Department of Primary Industries

OUT14/28712

Cobaki Estate Open Space Project (MP 08_0200 Mod.3) Proposed Modification

Figure 1 – Location of SSPP Fill Area and the Extension to the Precinct 9 Borrow Area

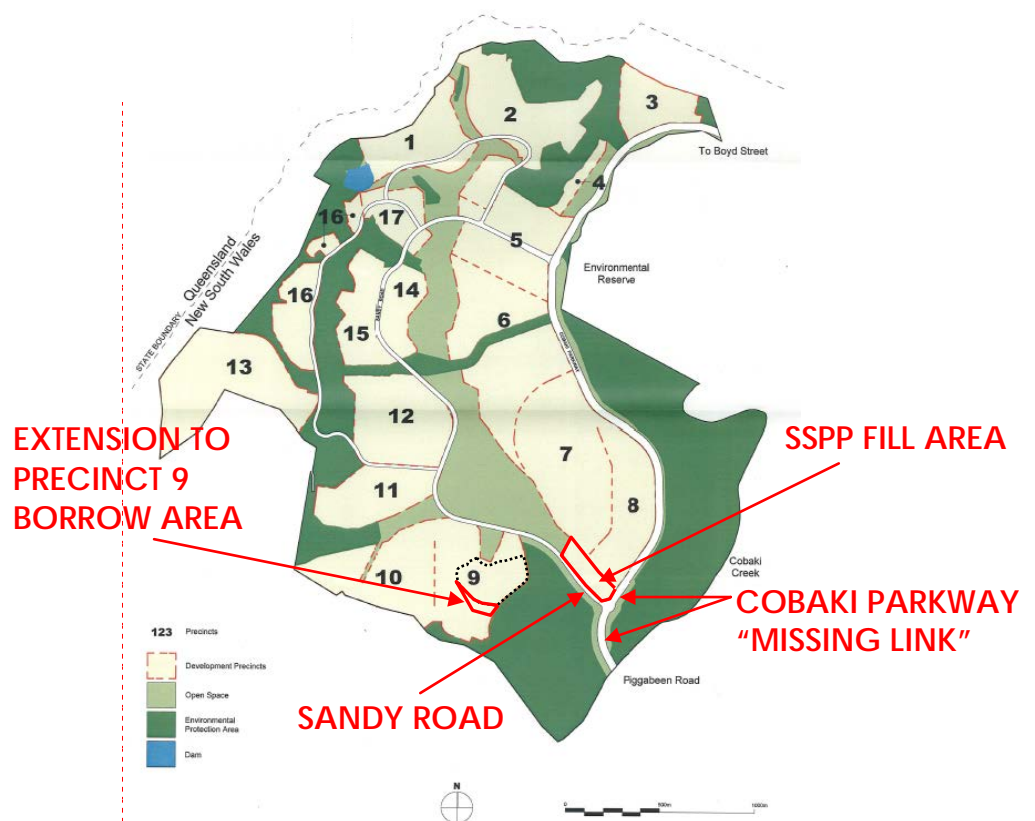
The expansion area for Precinct 9 Borrow Area is shown on the plans included in the Cobaki SSPP Environmental Assessment Report. It appears from the plans that the expansion encroaches on the areas of land set aside for rehabilitation and management and also the Saltmarsh Rehabilitation Area. It is important the relevant agencies have the opportunity to comment on this issue.
